<b>Consultation Response from KC, Highways Development Management</b>
<b>2024/93189 Unit 19-20, Headfield Mills, Savile Road, Savile Town, Dewsbury, WF12 9LQ</b>
<b>Erection of single storey extension, external alterations to shopfront to front and side elevation, change of use of part vacant area into class E Cafe and formation of car park access</b>
<b>Date Responded: 17-9-2025. Responding Officer: Mark Berry. Responding Ref: 15-1NW-4.</b>

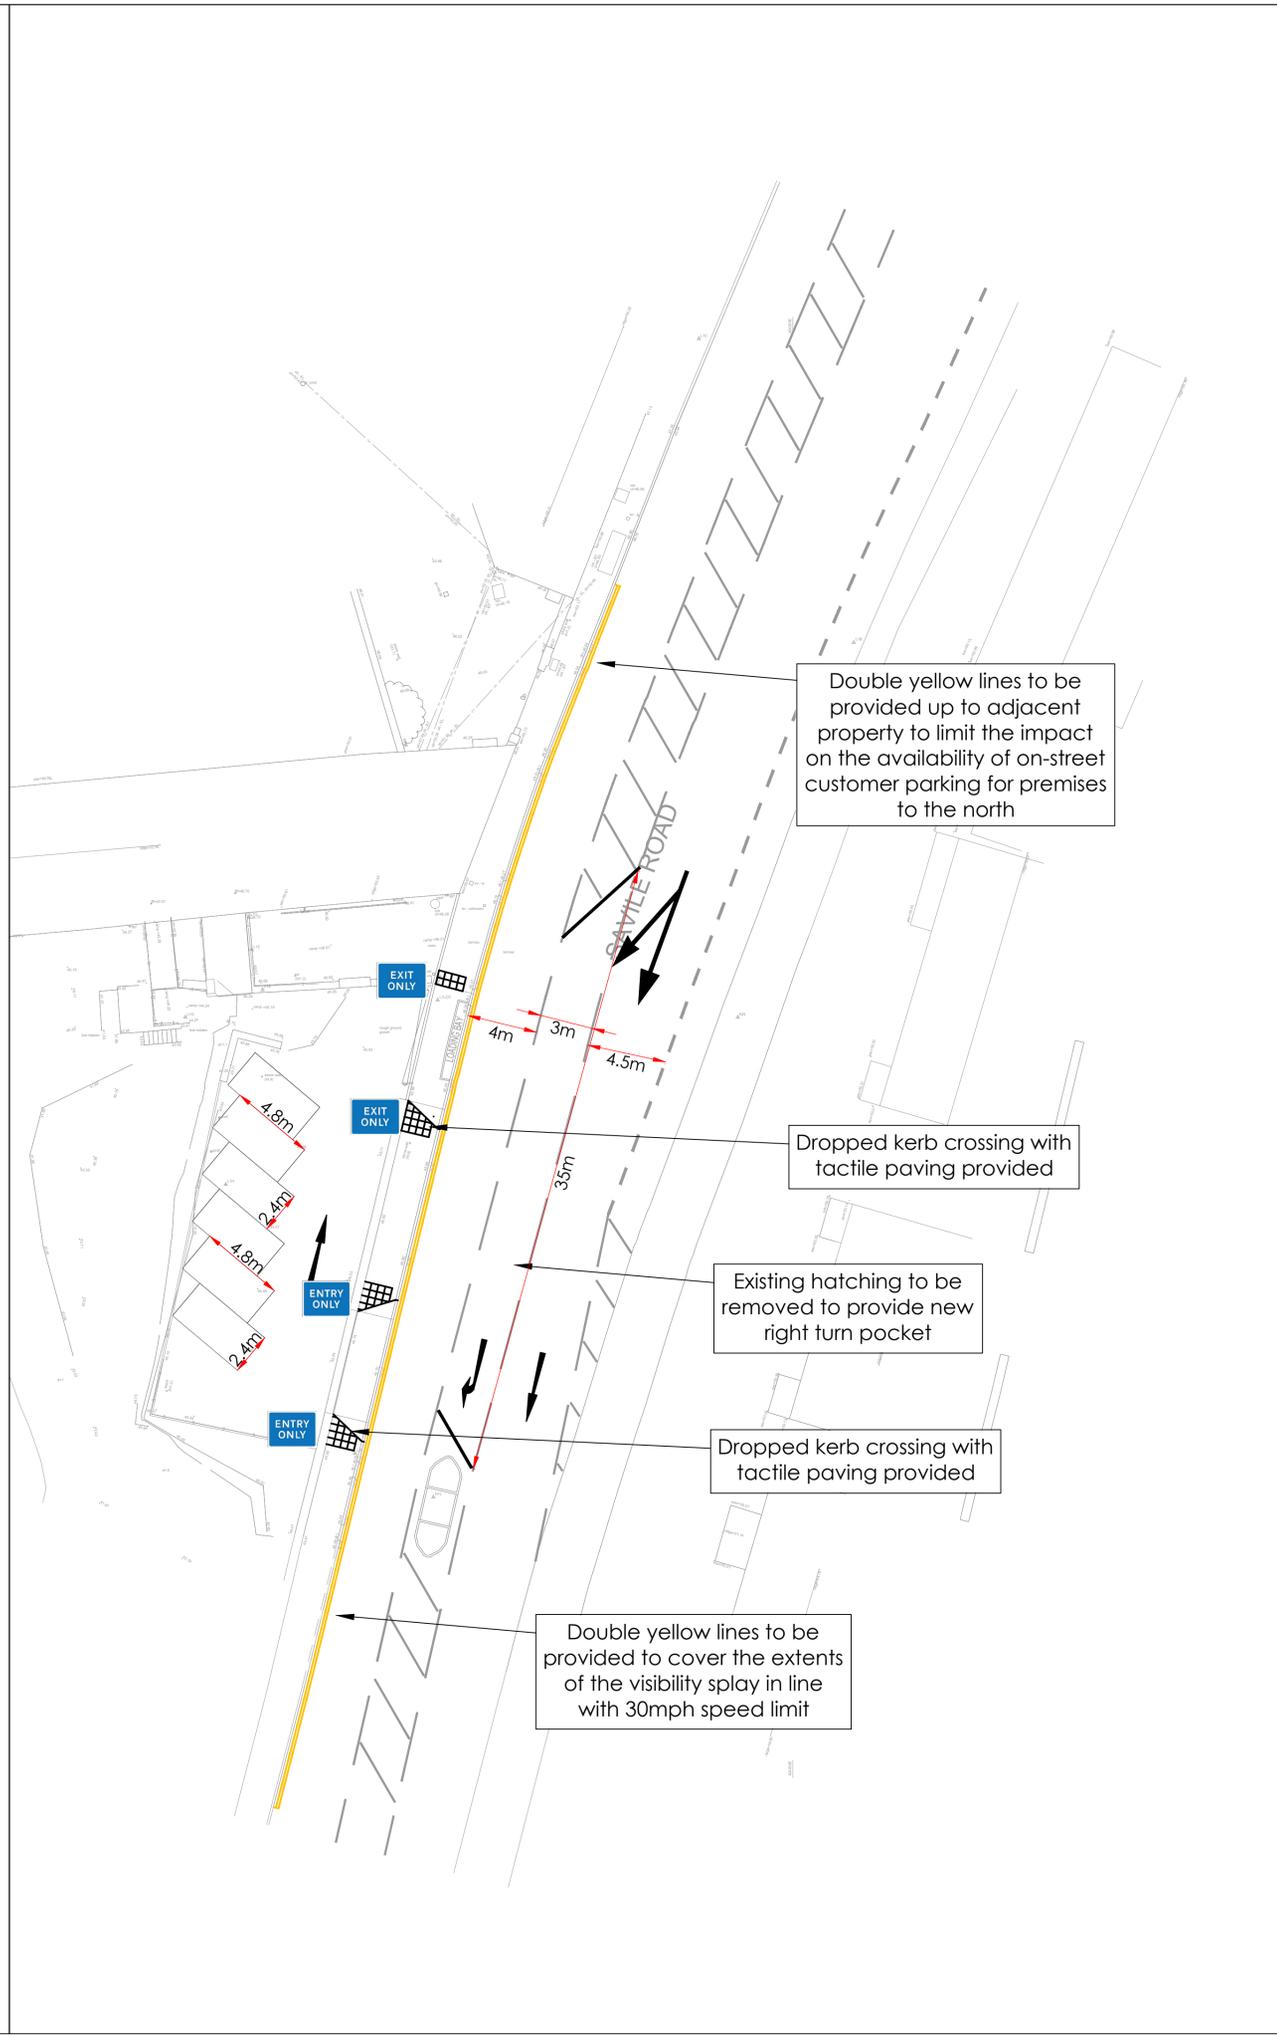
The extents of any DYLs needs to be agreed with Highways before the RSA is undertaken.

Before the RSA can be undertaken the proposed layout needs to show the extents of the proposed DYLs so that they can be considered. The extents of the DYLs need to be agreed in advance.

Project Headfield Mills, Savile Town, Desbury				
Title Car Park Access Design				
Date 29.09.25	Designed by JA	Checked by JT		
Drawing Number P3144 - D - 1002			Scale @ A3 1:250	Revision B

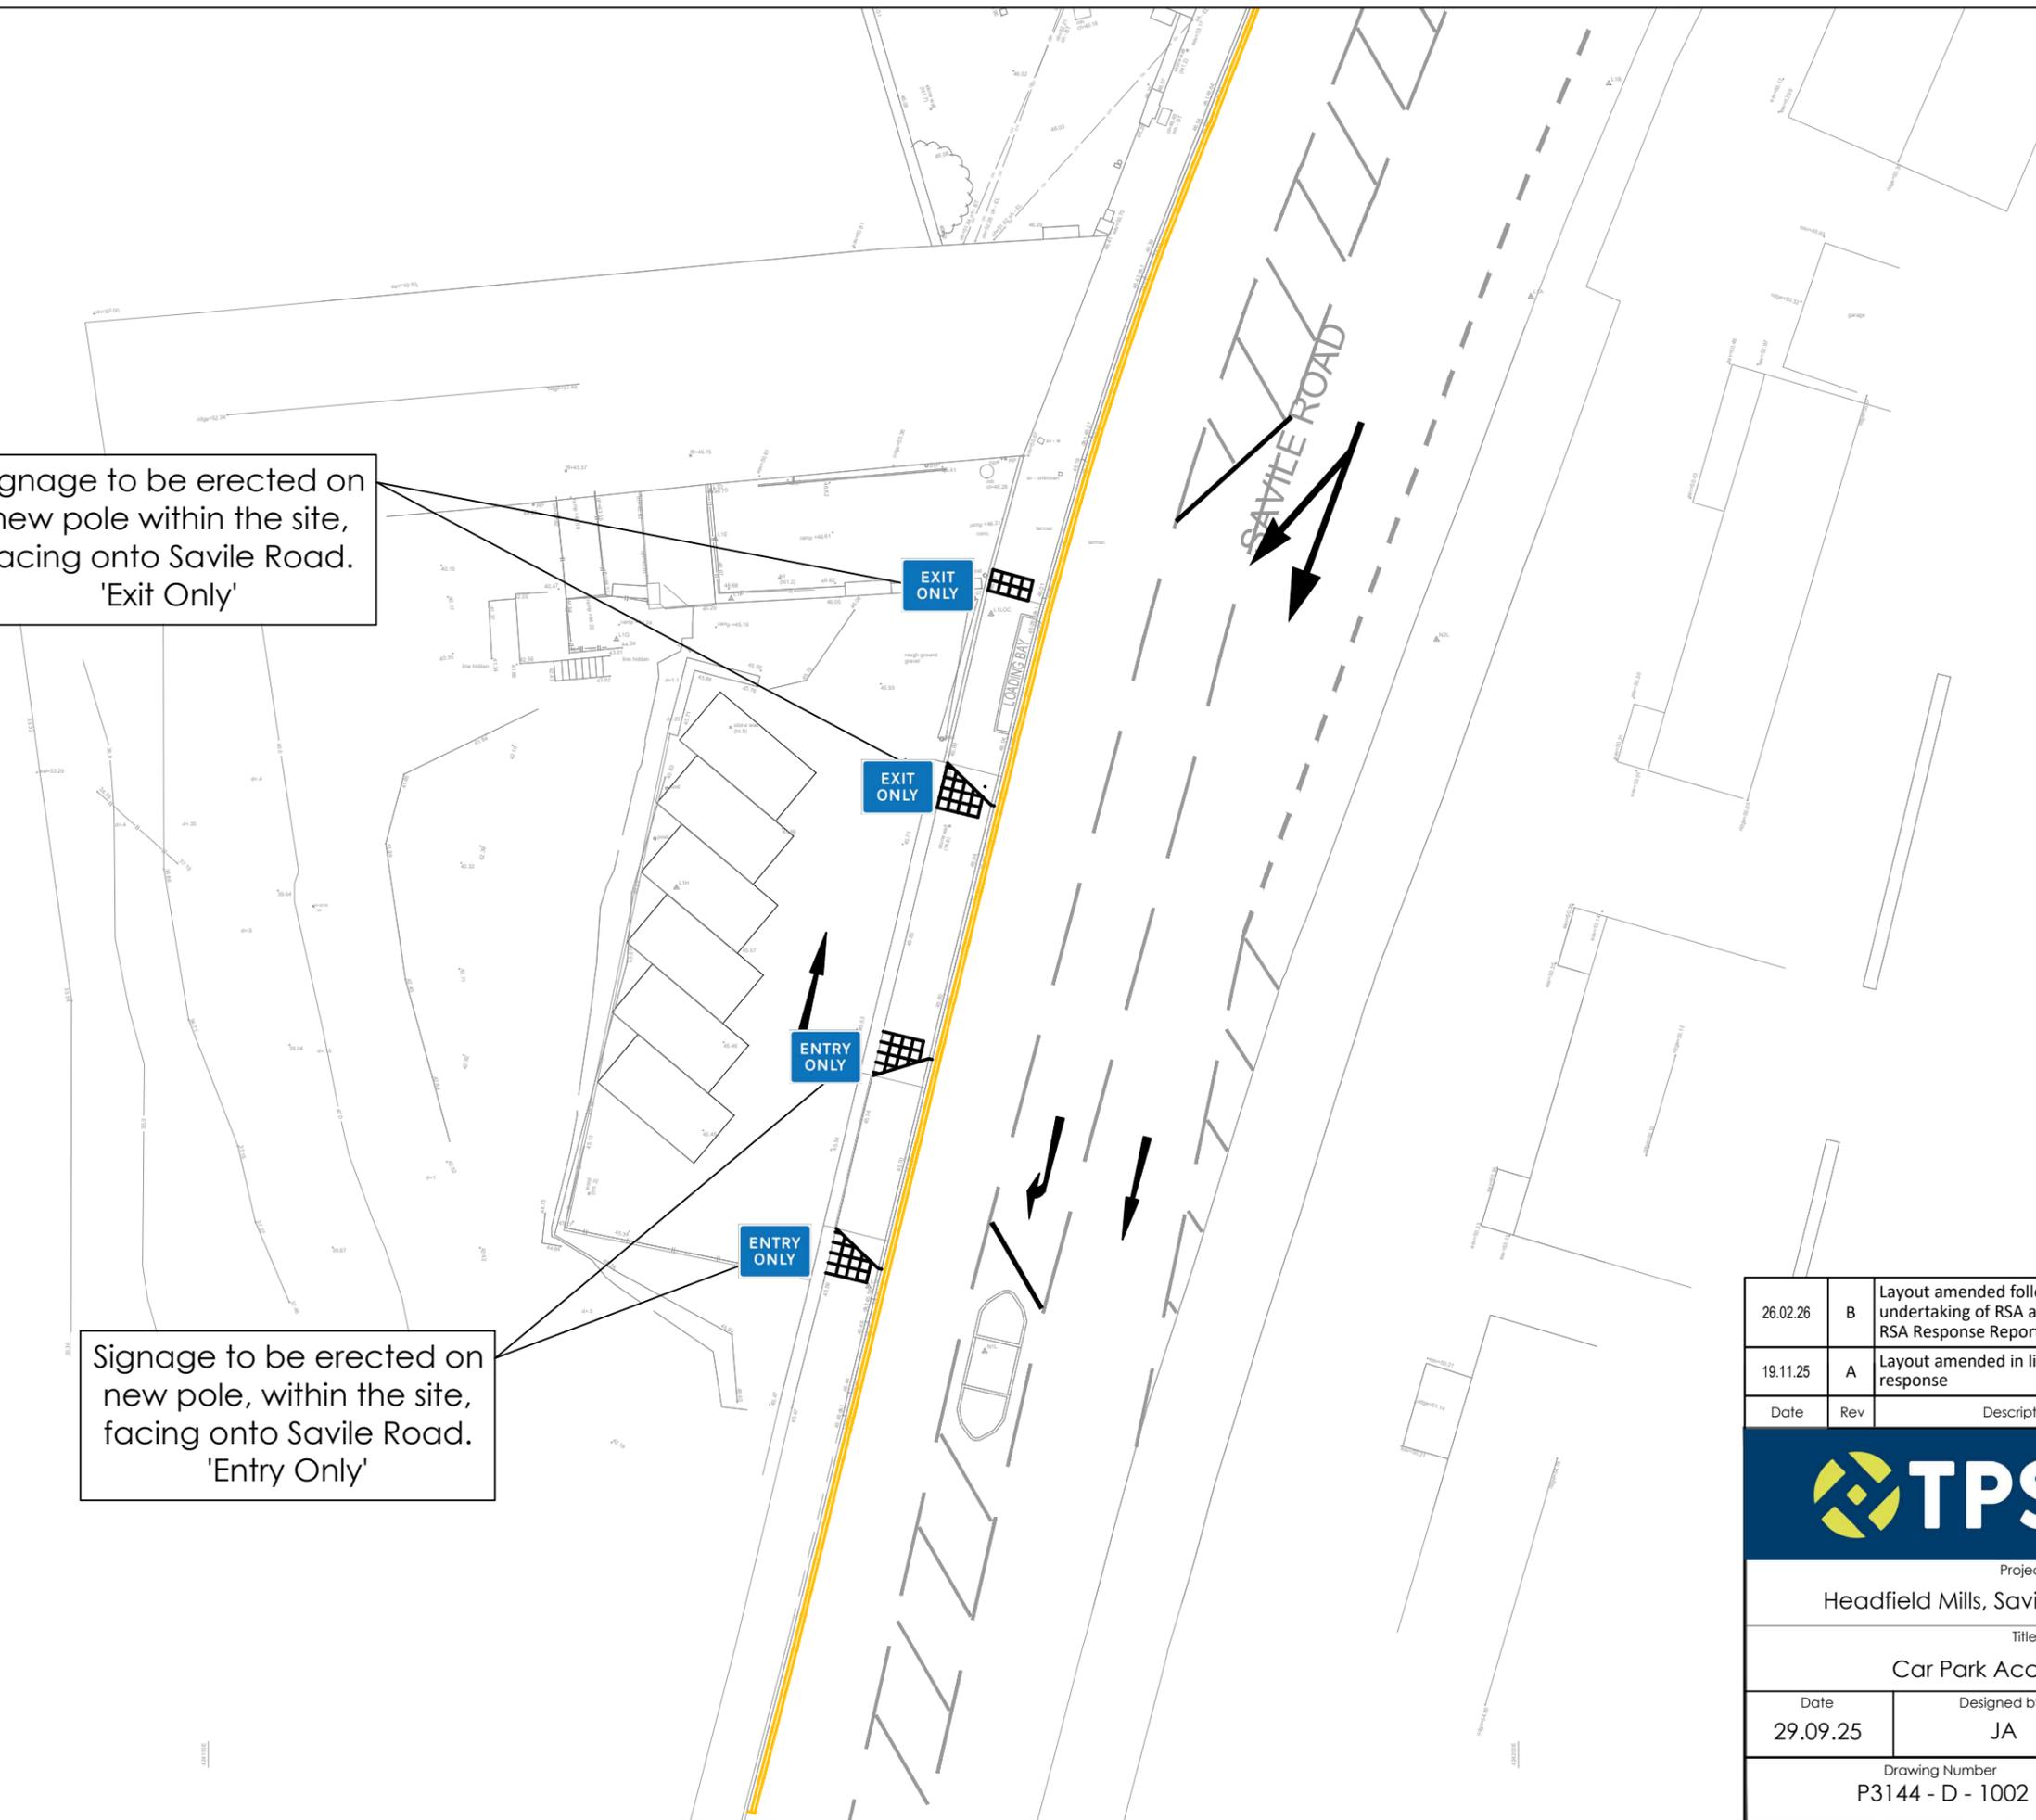
The centre line hatching needs to be shown on the proposed layout with a right turn pocket and arrow shown to be provided.

In and out signing and markings need to be shown on the proposed layout plan.
